# GOVERNMENT ARCHITECT NEW SOUTH WALES

Pitt Street South Over Station Development – Design Excellence

Sydney Metro Design  
Review Panel  
Letter of Design Excellence  
Pitt Street South Over  
Station Development

3D View\_ View from St Mary's Cathedral\_SSDA

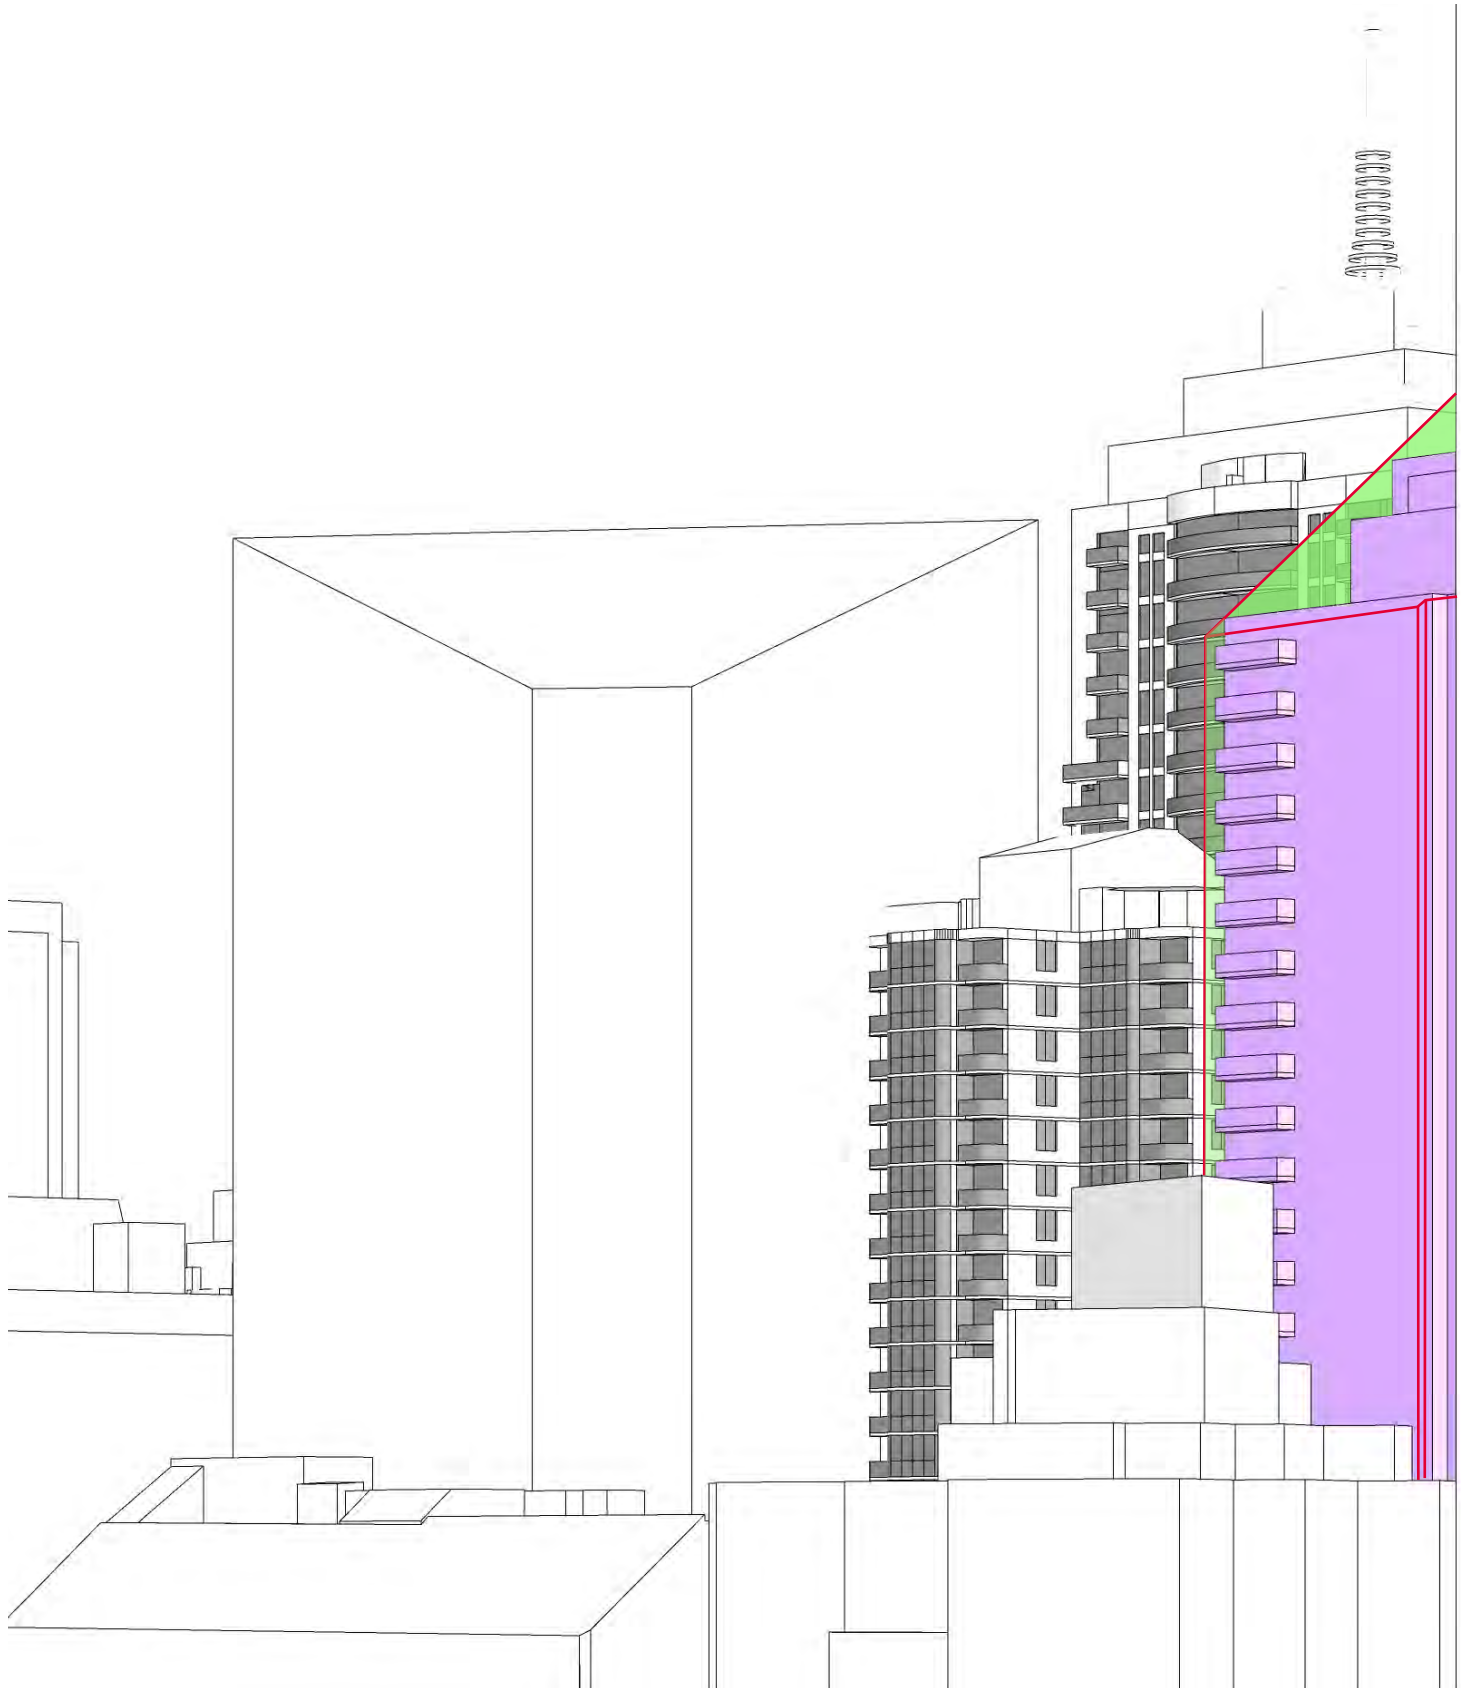
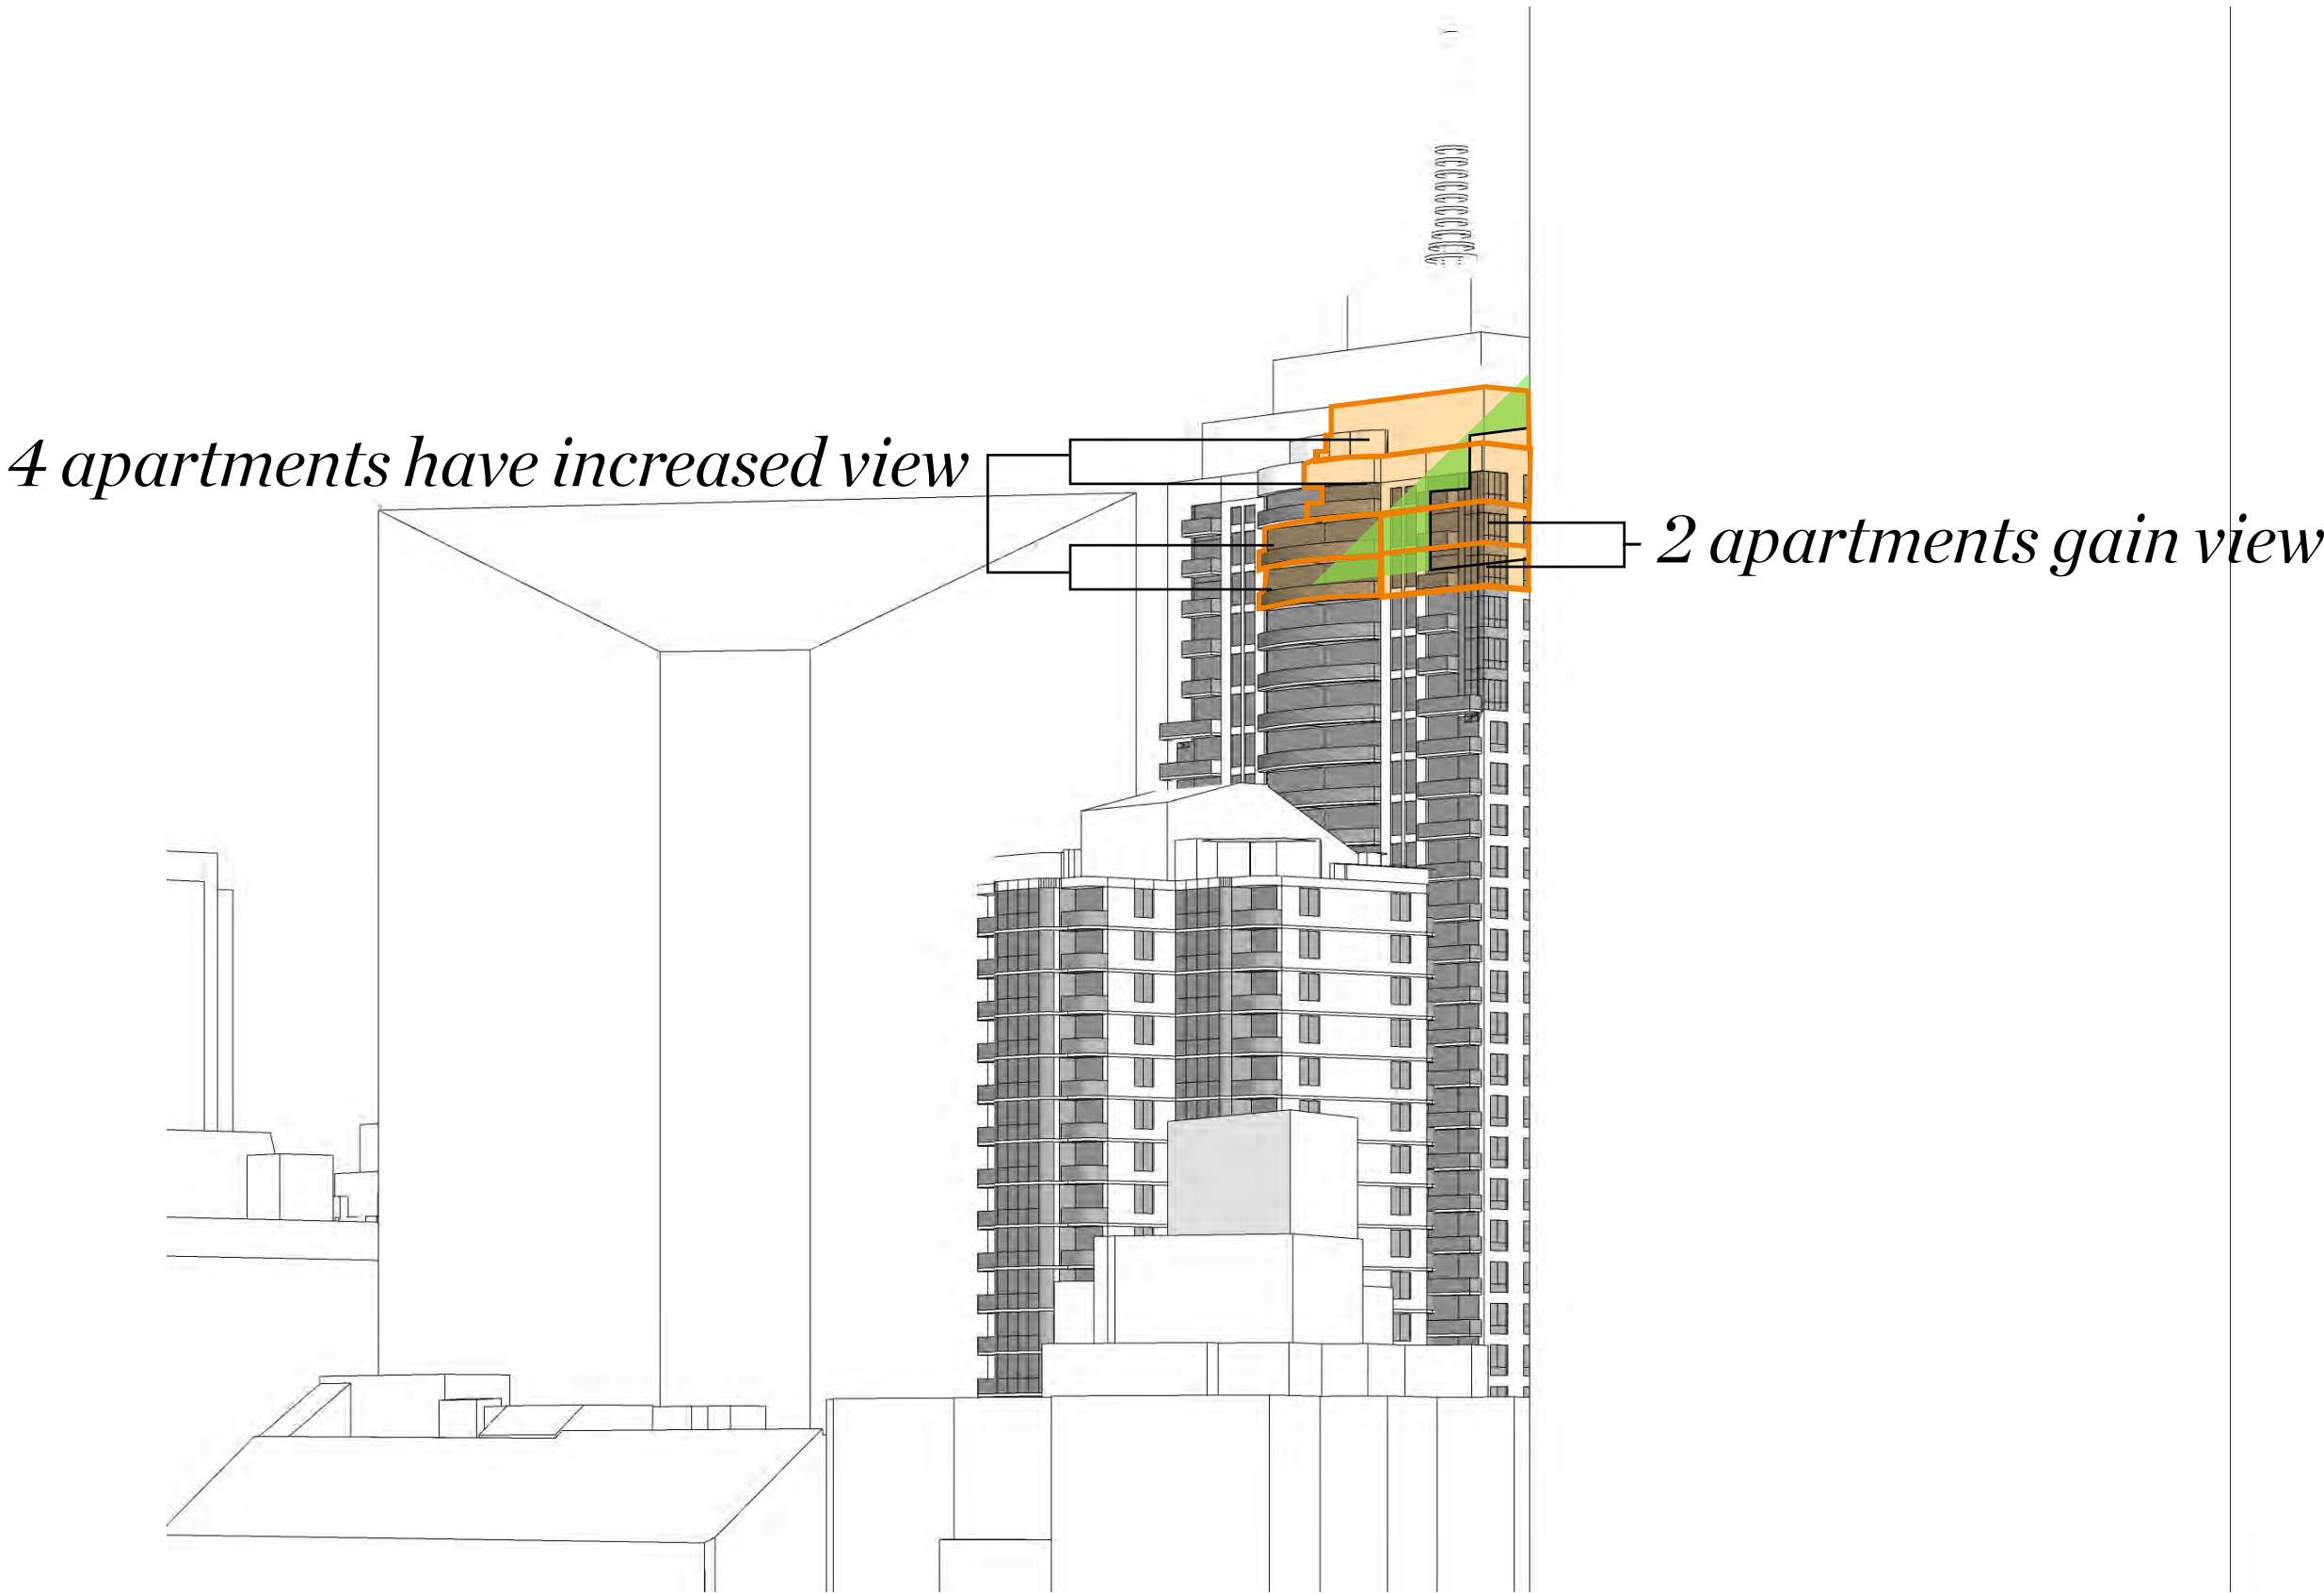
- The Panel accepts that a reasonable attempt has been made to increase the number of Century Tower apartments retaining views of St Mary's cathedral through articulation of the roof form within the approved planning envelope

PROPOSED SOUTH EAST APARTMENT

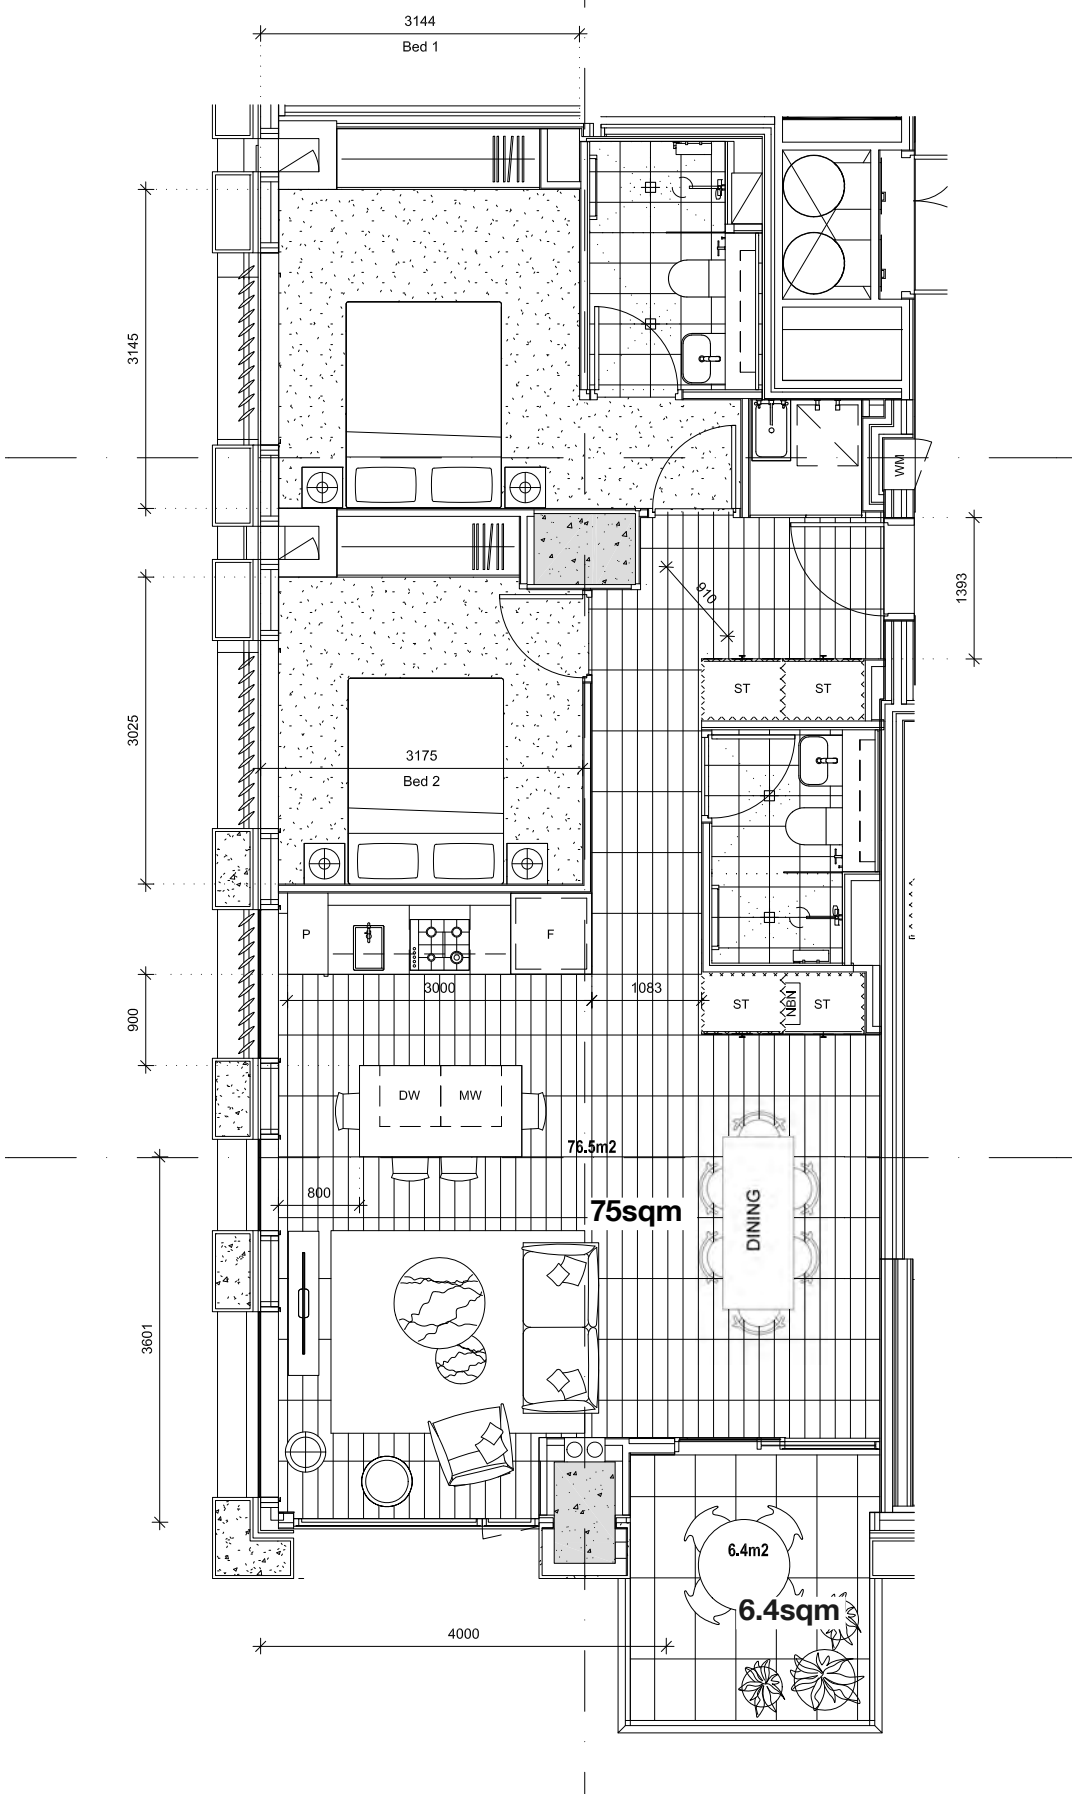
- Tracker Item 11.01: The Panel defers to DPIE for compliance decisions relating to overshadowing of Princeton apartments.
- Tracker Item 11.04: The Panel supports the improved amenity afforded to the SE corner apartments due to indenting the balcony, and the resultant reduction of balcony size.

- The Panel does not support the reduction in area to the SE corner apartments, and suggests the removal of the second bathroom to align the area with the Apartment Design Guidelines. However, the Panel supports the reduction in balcony area to improve privacy.
